Reference: Engineering Services
2152 Sheriff Johnson Road
Lillington, NC 27546
Project No.: 2001-020054

1. LVL beam sizing for proposed opening for home addition.

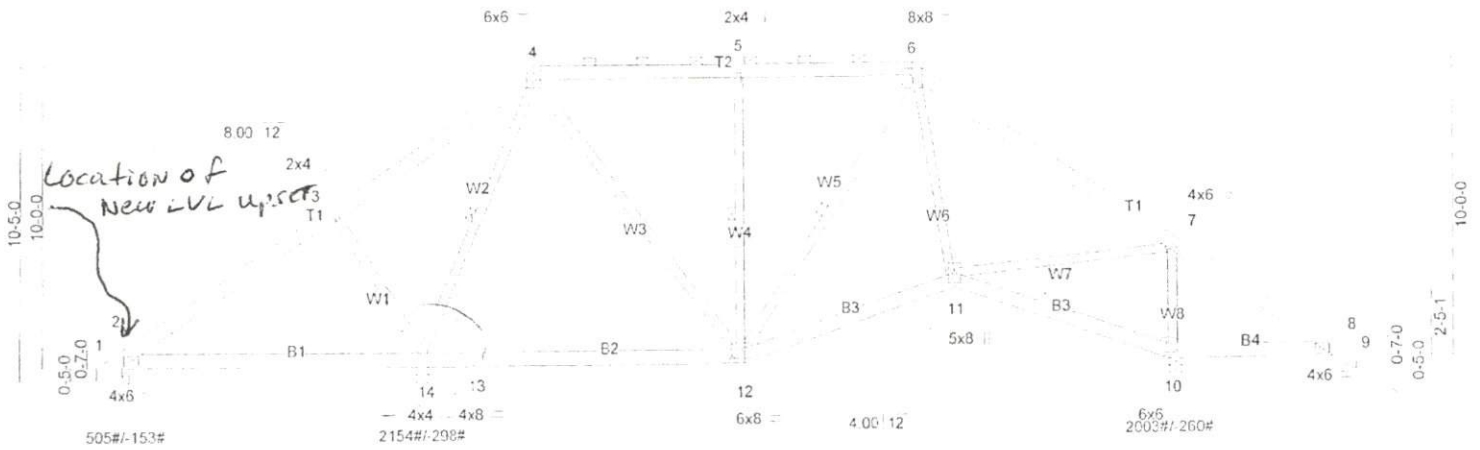
1. Based on our observations and analysis, TE&D recommends installing a (3) 1-3/4" x 18" LVL flush beam across the proposed opening. The non-structural "tails" at the ends of the trusses may be removed to tightly install the new beam. Gusset plates may not be modified, damaged, or removed. The new beam is to be supported with (4) 2 X 4 jack studs and (1) 2 X 4 king stud at each end. The stud columns are to be fastened with Simpson CS16 coil straps, installed horizontally, at 24" O.C. The new beam will provide the required support for the anticipated loading conditions.
